A417 Missing Link
TR010056

6.7 Environmental Statement -
Updates and Errata (Rev 2)

February 2022

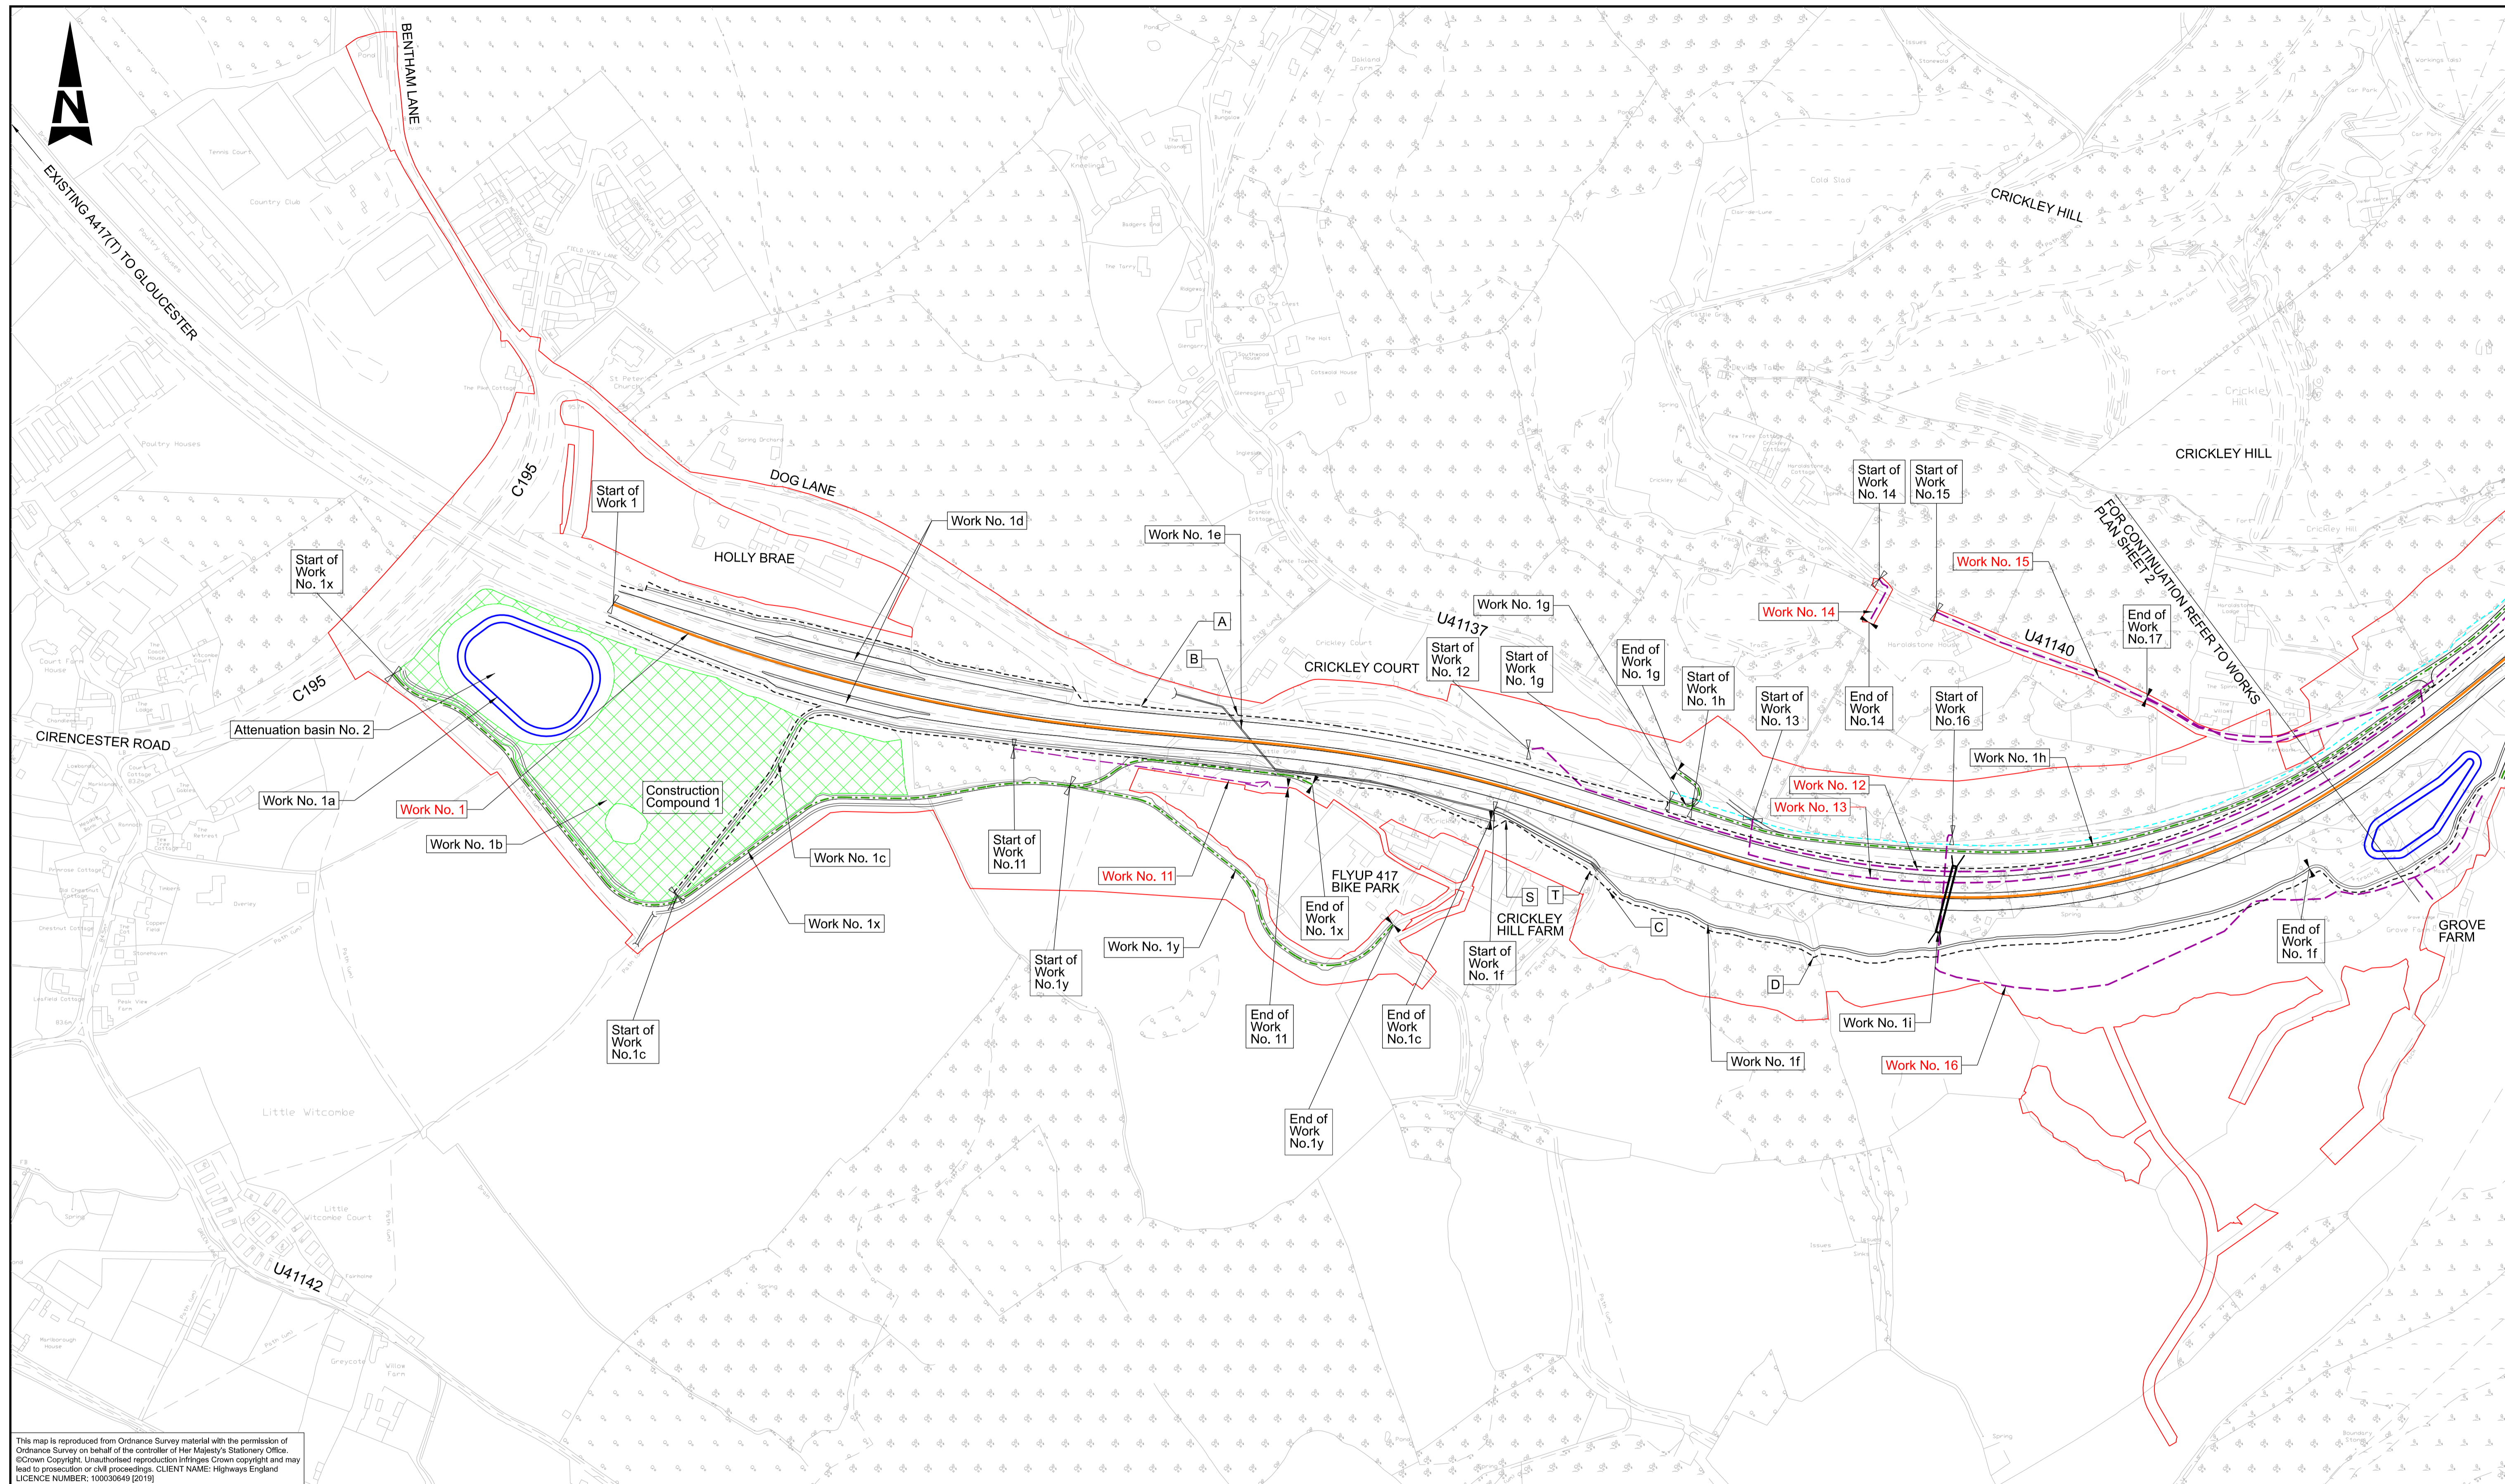
| Document reference | Reason for amendment to the ES | Amendment to the ES | | |
|--|---|--|------------------------------|---|
| Volume 6.2 Environmental Statement Chapter 2 The Project (APP-033) | Table 2-2 updated to include an additional restriction (<i>0m between points S and T on sheet 1 of the Works Plans</i>) to the lateral Limit of Deviation to ensure that the earthworks footprint will remain outside on the existing Flyup car park. | Table 2-2 Lateral LoD | | |

| Document reference | Reason for amendment to the ES | Amendment to the ES | | |
|--|---|--|------------------------------|---|
| | | 1 | A417 mainline | 1.0m between points A and B on sheet 1 of the Works Plans 0m between points C and D on sheet 1 of the Works Plans 0m between points S and T on sheet 1 of the Works Plans 0m between points G and H on sheet 2 of the Works Plans |
